RE: Intake Screening Comments
Project Name: 2436 74TH AVE SE
Project Address: 2436 74TH AVE SE
Building Permit Number: 2310-009

Please see the following itemized responses to the plan review comments.

A4.1

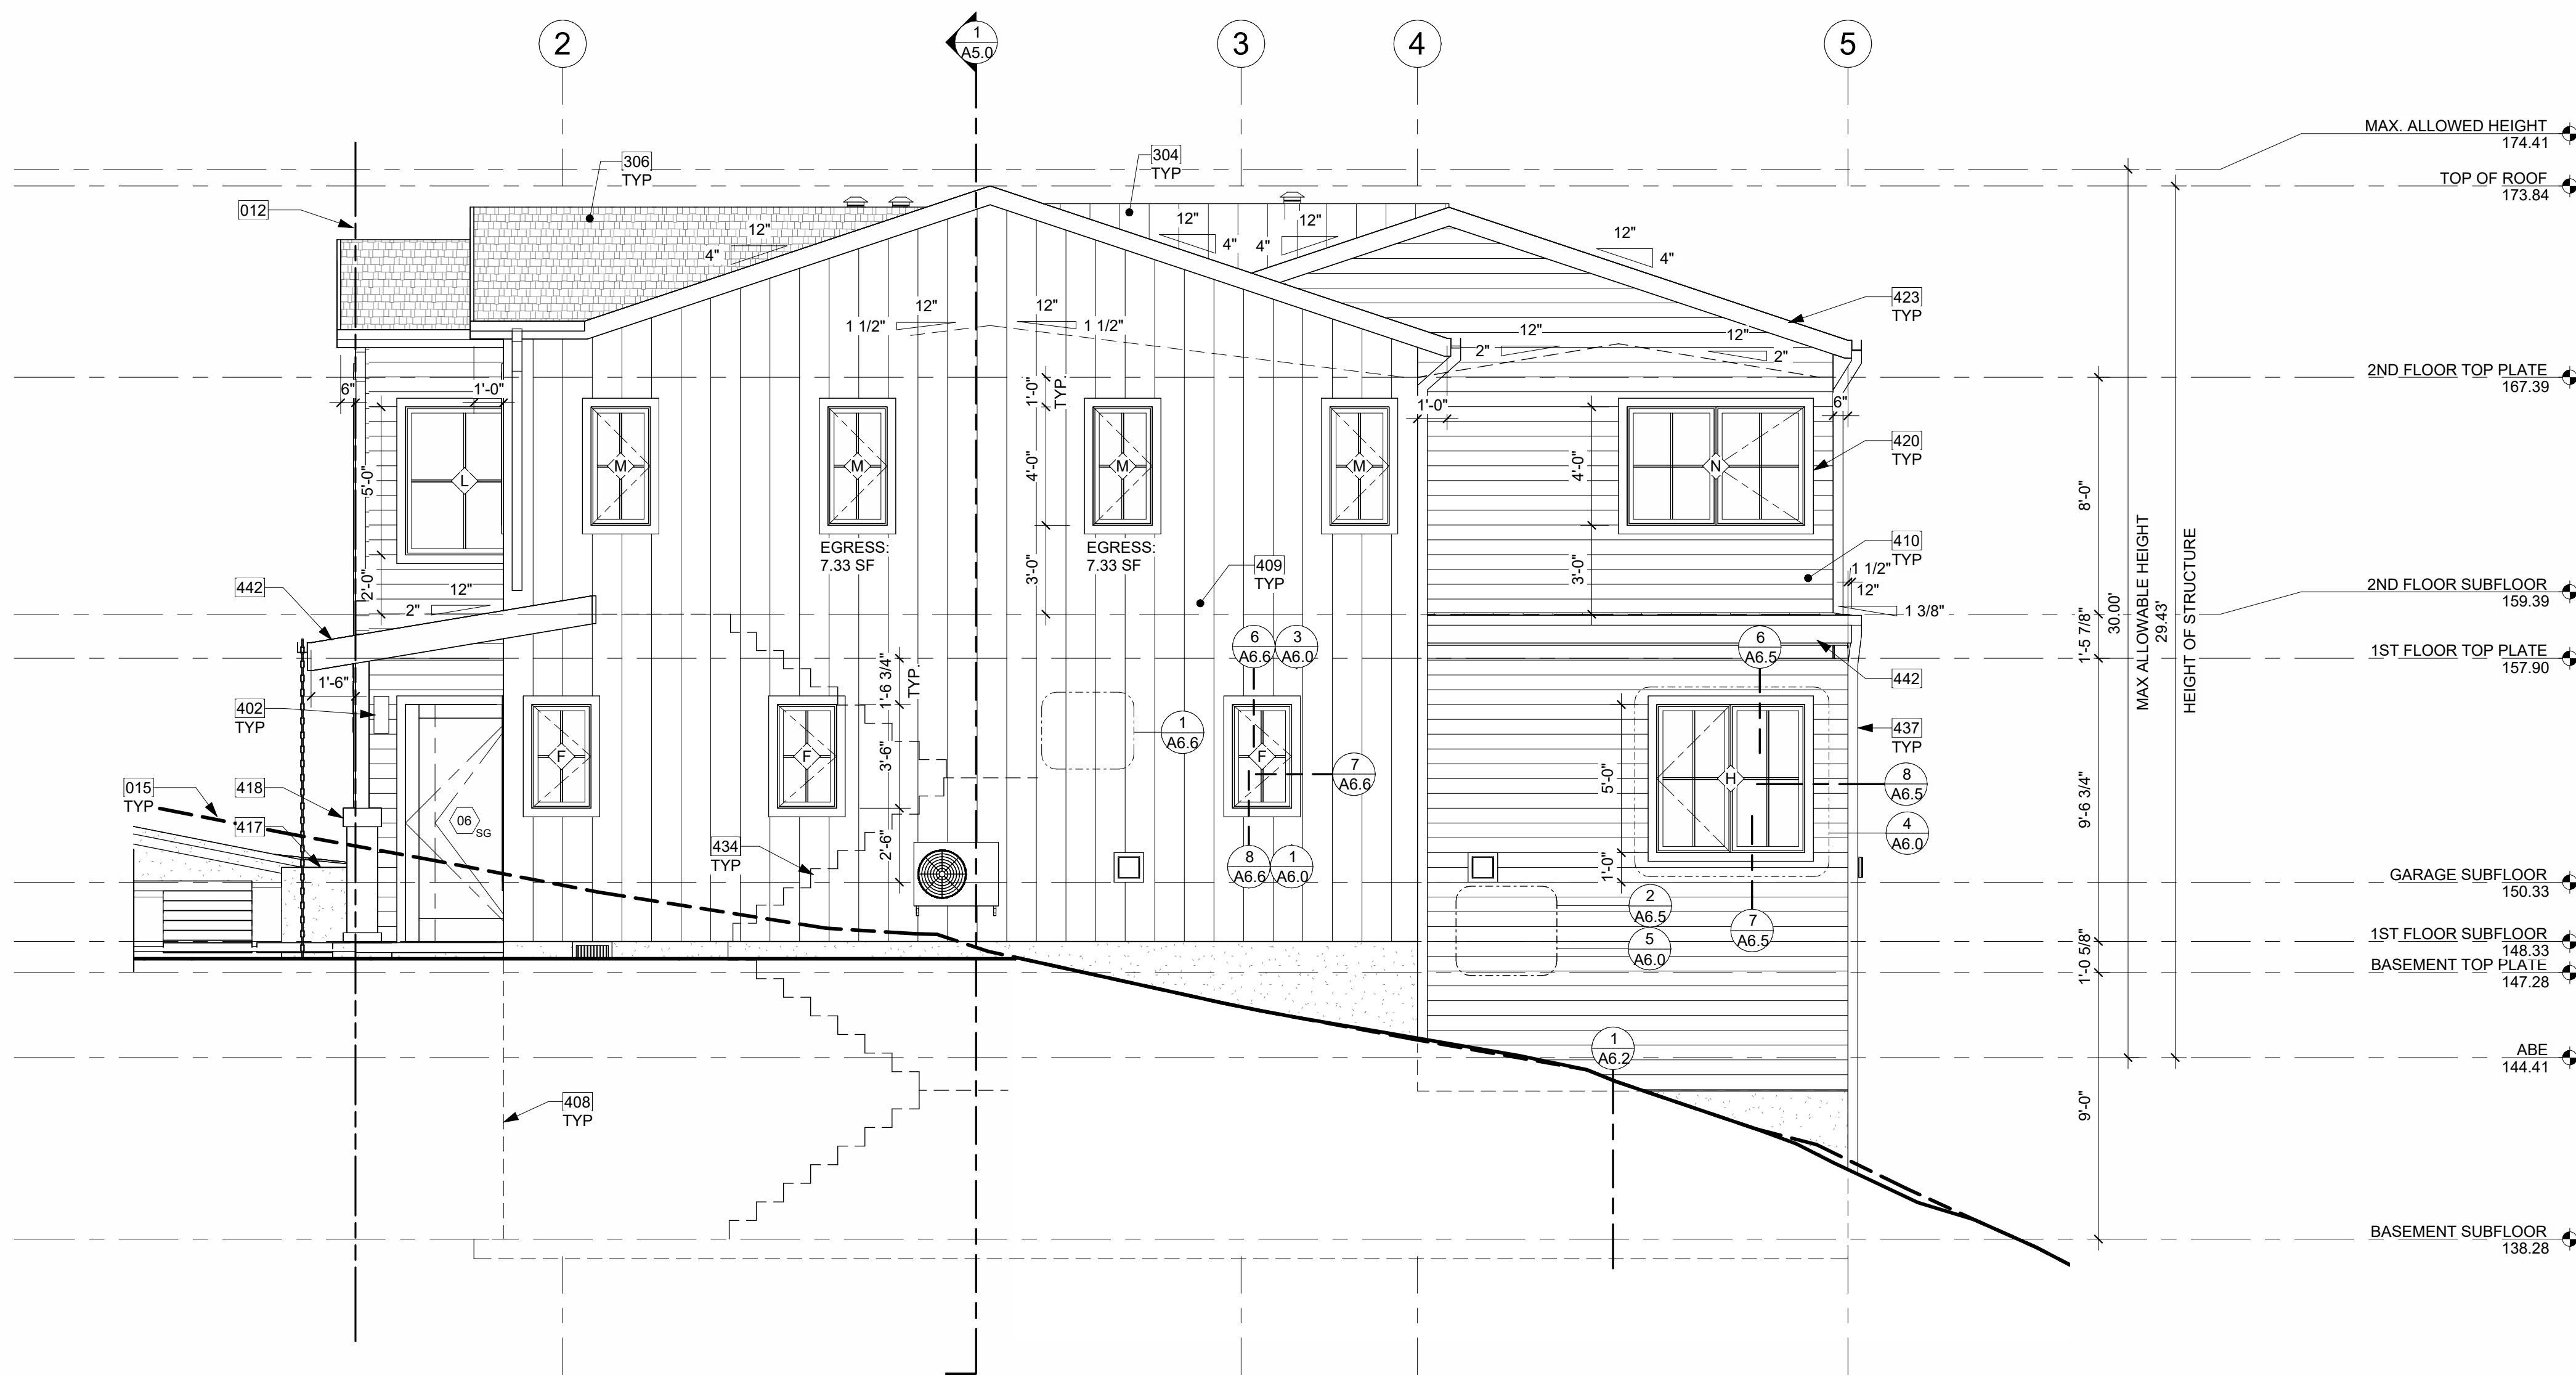
4. MICC 19.02.020(E)(2) limits the facade height on the downhill side of a house to 30 feet, as measured from the lower of existing or finished grade to the top of the exterior wall facade. The elevation on sheet A4.1 shows that the proposed facade height on the downhill side of the house exceeds 30 feet. Please revise the height of the wall to meet the 30-foot downhill facade height limit.

Façade height has been checked to be from top of wall (top plate where the roof structural members rest) to the lowest point of the grade, see sheet A4.1.
